13460  
30 July 2014

**SSD 4972 - SECTION 96 APPLICATION NO 3 (MODIFICATION 3)  
FOUR POINTS BY SHERATON, 161 SUSSEX STREET, SYDNEY**

**1.0 RESPONSE TO SUBMISSIONS**

Drawing Number
A-DA-0004

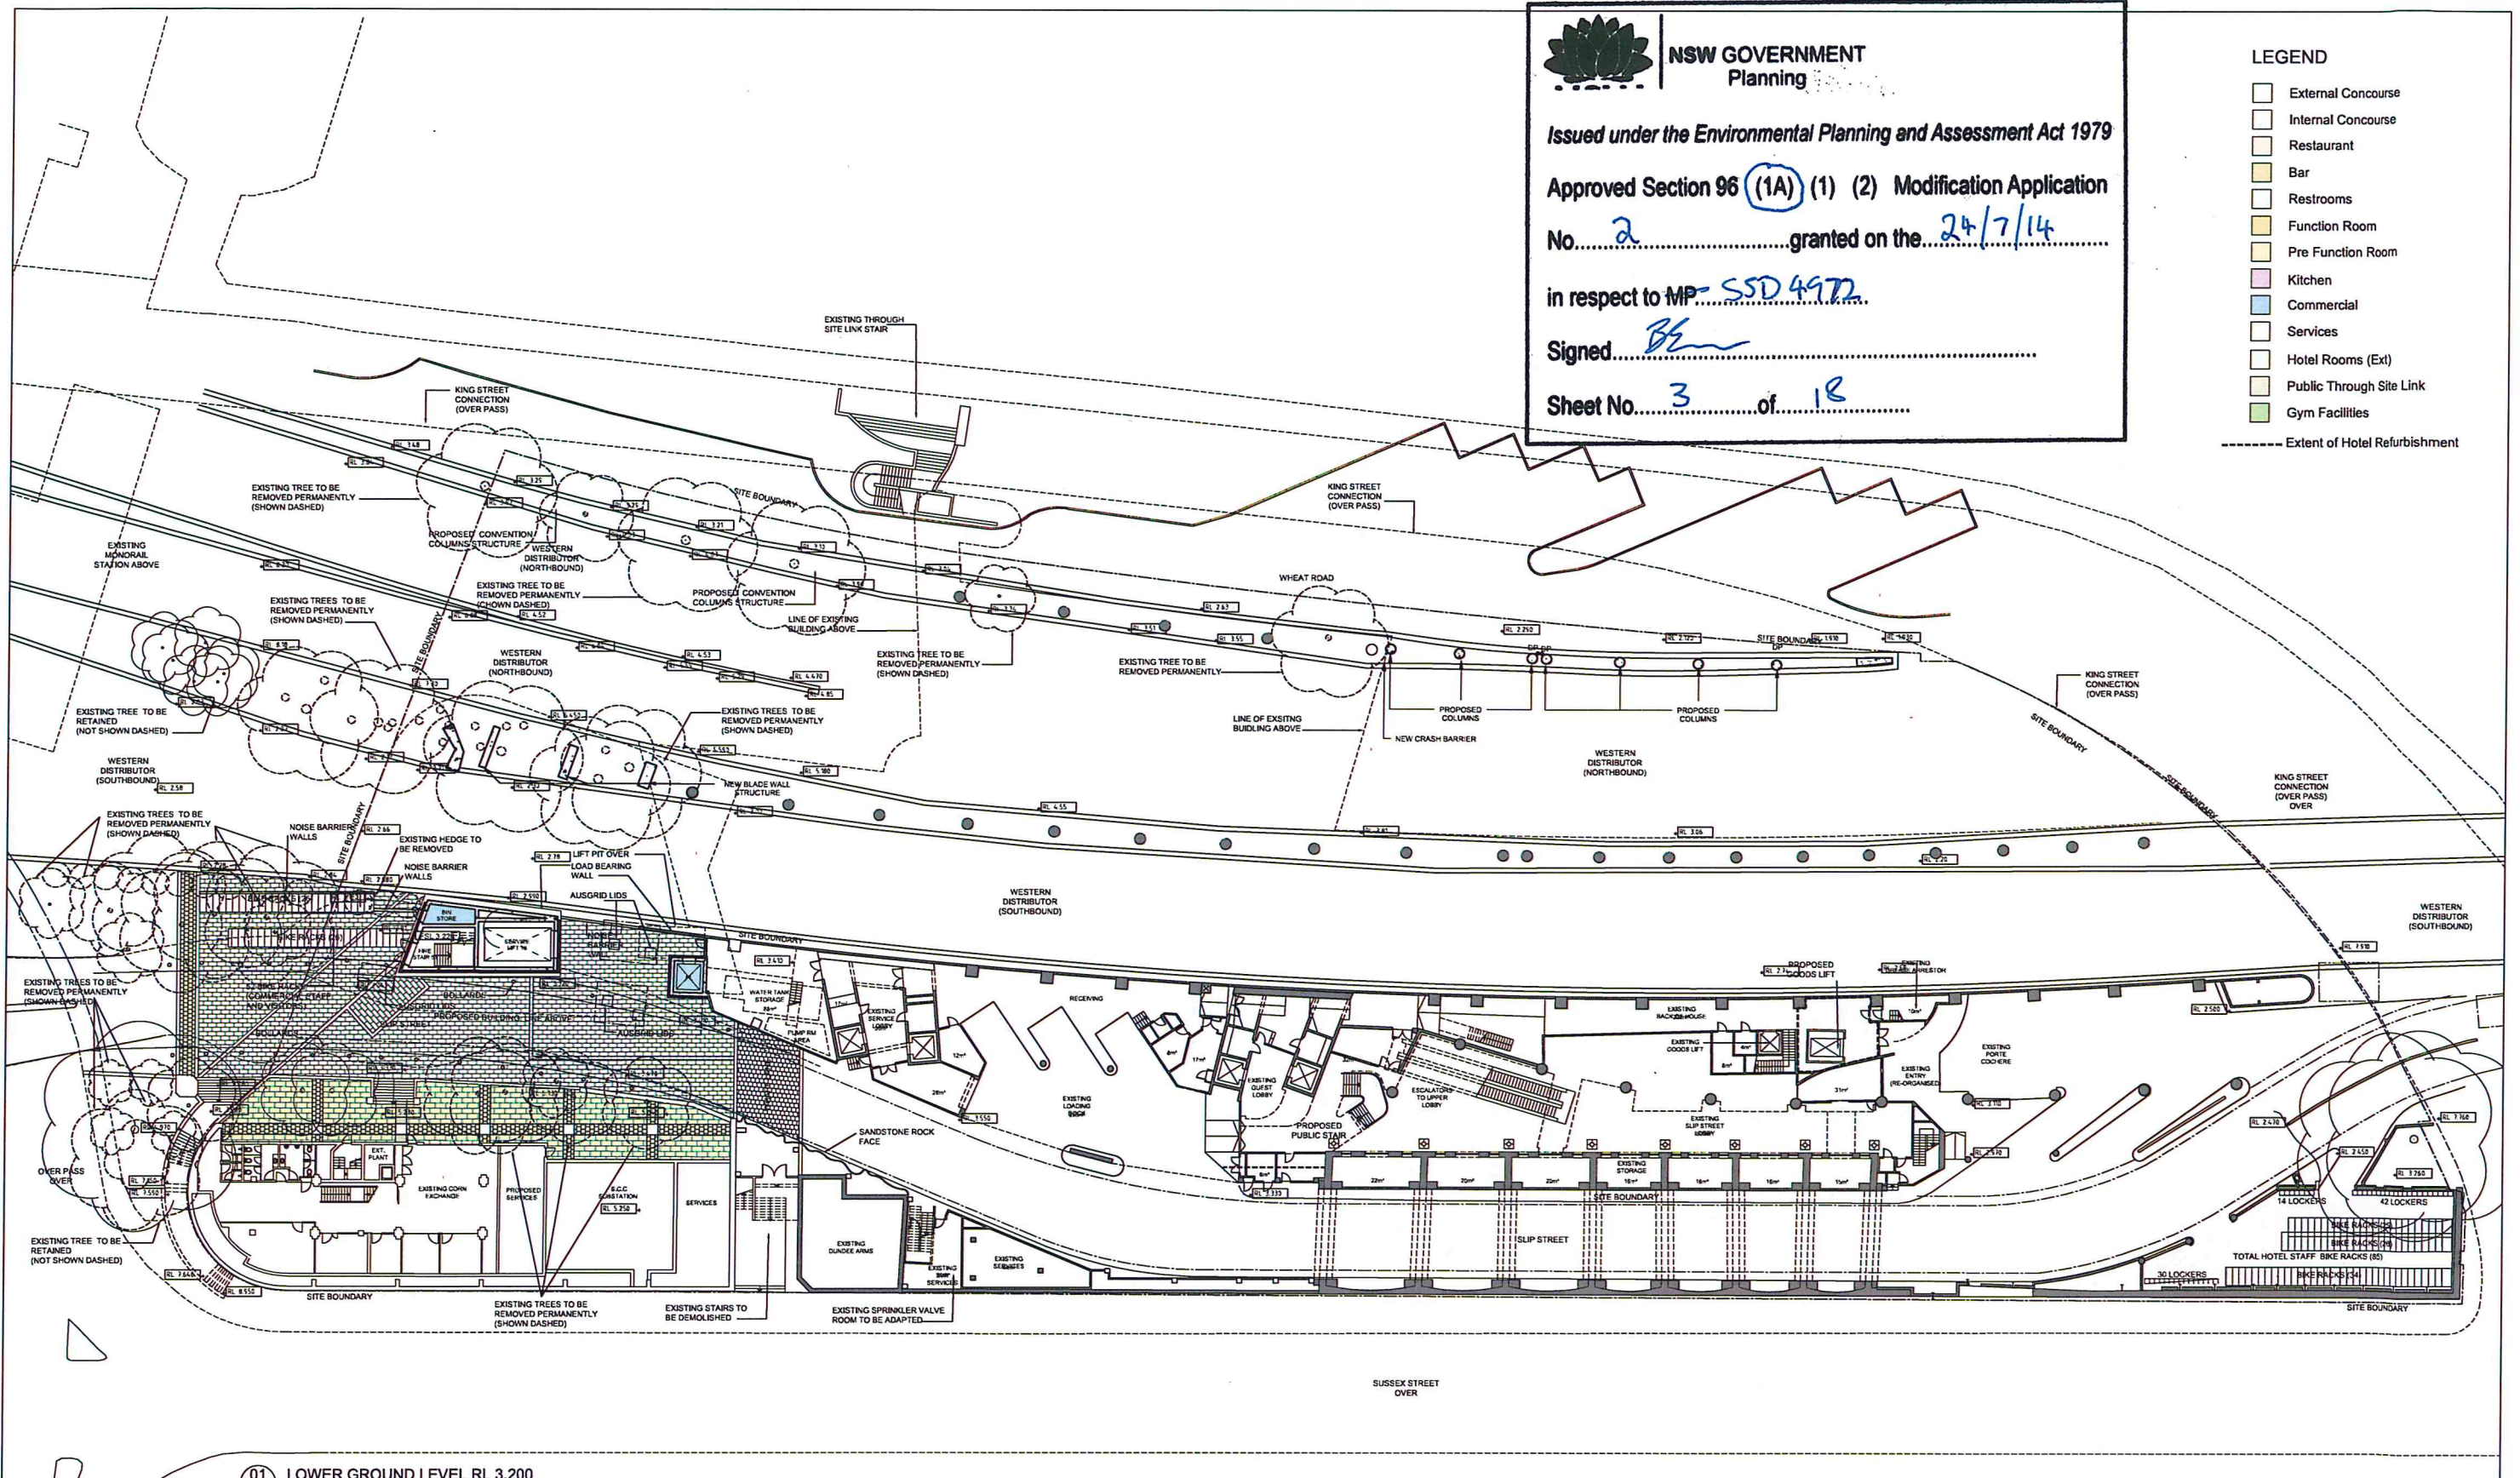
MOD 3 included changes to the design of the porte cochere. Subsequent to this, and as a result of design development, a further change is proposed with the introduction of a solid bay to replace the glass bay on the northern side of the porte cochere adjacent to the guest lift lobby and the bell desk. The proposed change was discussed with the CoS at the officer meeting referred to in Section 1.3 above, and was supported.

This amendment addresses the following design issues:

- Circulation space around the existing guest lift lobby: congestion in this space is reduced by clearly delineating the hotel entry and guest lobby egress with the introduction of solid cladding at the interface with the guest lift lobby - which in turn relates directly to the bell desk.
- Views of the hotel entry from Sussex Street: the provision of a solid bay in the porte cochere provides a clear architectural expression and symmetrical/ centralised hotel entry when viewed from Sussex Street.

The change also acts to concentrate the double height glass volume at the guest lobby instead of at the lift lobby.

The following drawings have been amended to reflect the modified design and replace the drawings with the same number lodged with MOD 3 (see **Attachment F**).

- A-DA-004 – Rev F
- A-DA-201 – Rev P
- A-DA-202 – Rev P
- A-DA-203 – Rev Q
- A-DA-204 – Rev P
- A-DA-302 – Rev L
- A-DA-312 – Rev E.
